Tritax Symmetry (Hinckley) Limited
**HINCKLEY NATIONAL
RAIL FREIGHT INTERCHANGE**

**The Hinckley National Rail Freight
Interchange Development Consent Order**
Project reference TR050007

**Applicant's response to Deadline 6 Submissions [part 10
- Residents Businesses]**

Document reference: 18.20

Graph 2. Noise Measurements at NMP4

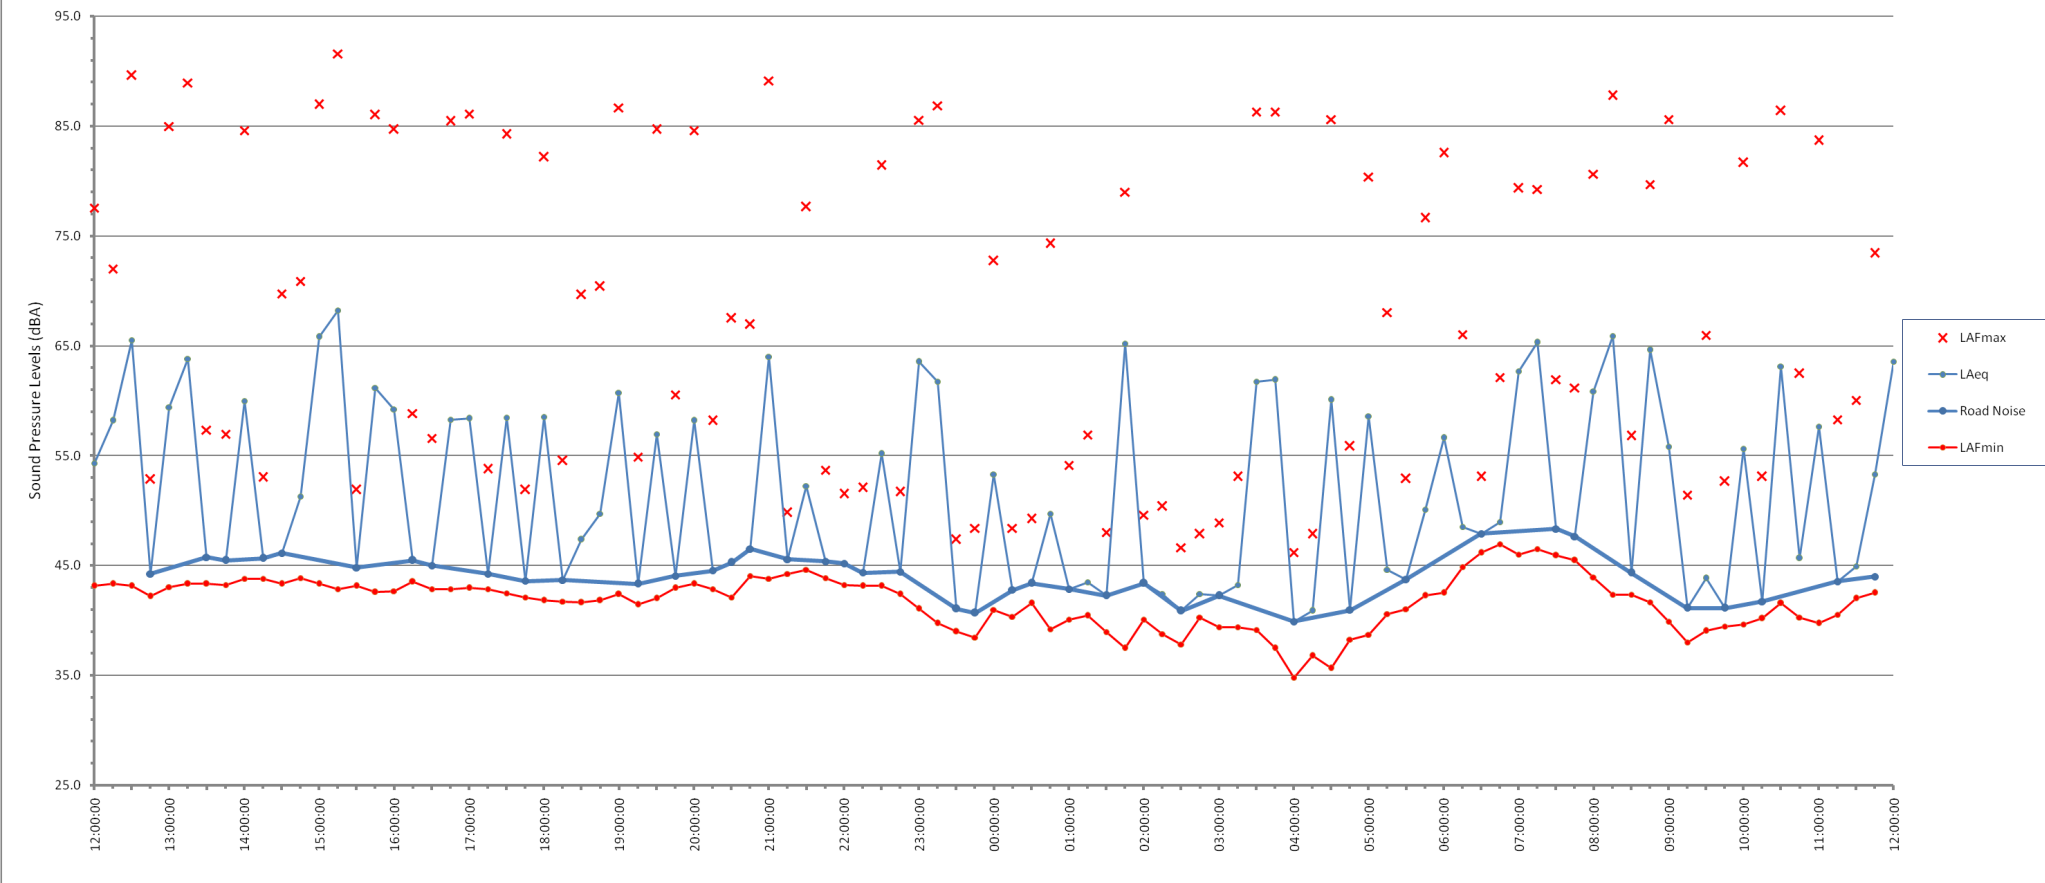
<p>Comments on Applicant's Written Statement of Oral Case at ISH6 by William David Moore</p>	
<p>6a Baseline Noise Conditions</p> <p>The ambient sound of the distant road noise has been measured by NMP4 & NMP3. The ambient sound of train pass bys have been measured by NMP4 & NMP3. Those ambient sound levels have then been copied to the NSRs associated with NMP4 & NMP3.</p>	<p>The comments refer to the baseline noise conditions and existing train movements, and the Applicant has already responded on that matter. This remains a point of disagreement. The Applicant has previously responded to comments regarding the baseline noise conditions and existing train movements at Deadline 5 - Applicant's Response to Deadline 4 Submissions [part 11 - Response to Mr Moore and Dr Moore] (document reference: 18.17, REP5-050), and through Issue Specific Hearing 6, summarised in the Applicants Written Statement of Oral Case (document reference: 18.15, REP5-025)</p>

Comments	Applicant's Comment																																			
<p>But the NSRs aren't in extremely close proximity to the railway line, so attenuation corrections need to be applied to the sound of the train pass bys measured by NMP4 & NMP3.</p> <p>The applicant has refused to do this. Instead, the applicant is attempting to rely on the applicant's road noise contour map and DEFRA strategic rail noise contours, neither of which are levels measured at the site by NMPs.</p> <p>The applicant is attempting to use those contours to make claims about ambient sound levels at some NSRs.</p> <p>The applicant's own report acknowledges the applicant's road noise contours overstate ambient sound levels versus those measured by NMPs. The strategic rail noise contours introduced by the applicant also overstate ambient sound levels versus those measured by NMPs.</p> <p>This is why the applicant should use measurements made by NMP4 & NMP3 during different time periods, and attenuate the sound of the rail noise measured by NMP4 & NMP3 during different time periods.</p> <p>Instead, the applicant is making claims using contours which are known to overstate ambient sound levels.</p>																																				
<p>During the meeting, I made three points which the applicant did not address on the day, and which the applicant hasn't addressed in the written statement of the applicant's oral case at ISH6. Those are:</p> <ol style="list-style-type: none"> 1. The applicant's noise assessment update note doesn't address all the NSRs associated with NMP4. 2. The applicant has misstated the locations of NSRs 2, 3 & 4. Those NSRs should not have been included in Table 5 of the applicant's update note and the applicant's claims relating those NSRs can be discarded. 3. The applicant has attempted to attribute 50 dB of rail noise to the NSRs in Table 5, but all the NSRs in Table 5 are outside the rail noise contours introduced by the applicant. 	<p>It is assumed that this refers to the resultant noise levels at NSRs 1 and 24 which are now shown below</p>

<p>The Applicant has provided a further response to the Rule 17 Letter received 20th February in the Hinckley NRFI Noise Note Response to ExA Rule 17 letter (document reference: 22.3) submitted as part of Deadline 7.</p> <p>The Applicant has previously responded to this comment through the Applicants Written Statement of Oral Case (document reference: 18.15, REP5-025). This remains a point of disagreement.</p>	NSR	Daytime (0700-2300)				Night-time (2300-0700)				Rating Level	Ambient Level	Rating + Ambient	Increase	Rating Level	Ambient Level	Rating + Ambient	Increase	1	47	56.2	56.7	+0.5	47	54.8	55.5	+0.2	24	50	56.2	57.1	+0.9	47	54.8	55.5	+0.2
NSR	Daytime (0700-2300)				Night-time (2300-0700)																															
	Rating Level	Ambient Level	Rating + Ambient	Increase	Rating Level	Ambient Level	Rating + Ambient	Increase																												
1	47	56.2	56.7	+0.5	47	54.8	55.5	+0.2																												
24	50	56.2	57.1	+0.9	47	54.8	55.5	+0.2
